AW/187/18/PL & AW/188/18/L

Extension of garage to form single storey 1 bedroom residential unit for elderly relative & short term lets

2. ELEVATIONS

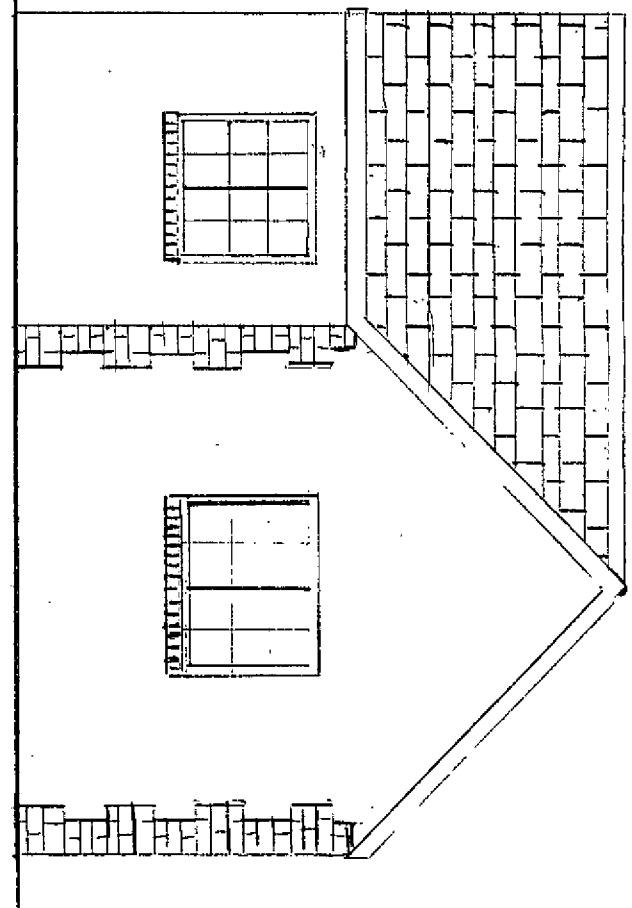
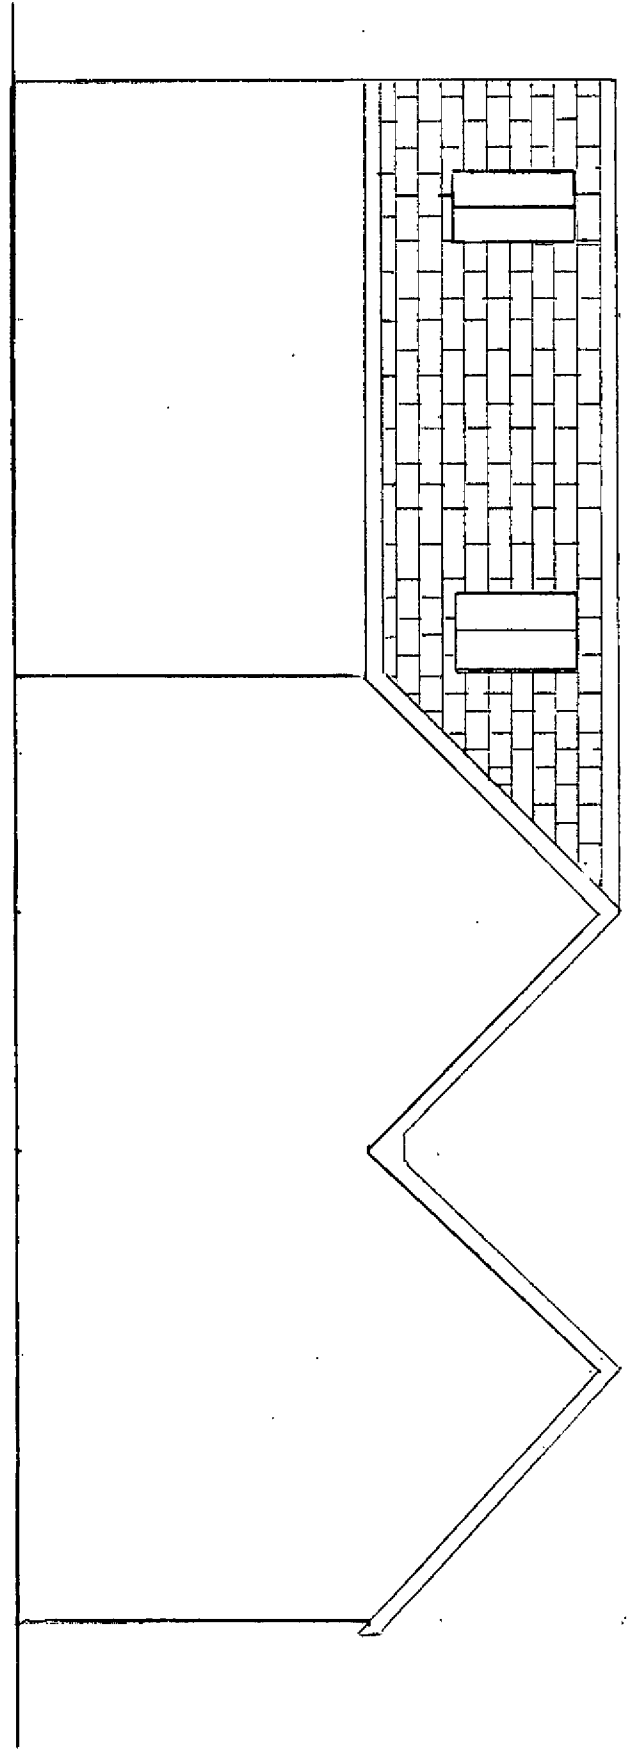
The proposed plans maintain the appearance of the existing garage structure, and have very limited visibility from the street-scene or the listed building. The impact will therefore be a neutral one. The success of such a scheme will depend upon the quality of the material to be used.

Materials should be appropriate to the listed building, as opposed to those identified as part of the planning application form. Therefore, if minded to approve the application, details of joinery and material should be provided by way of condition.
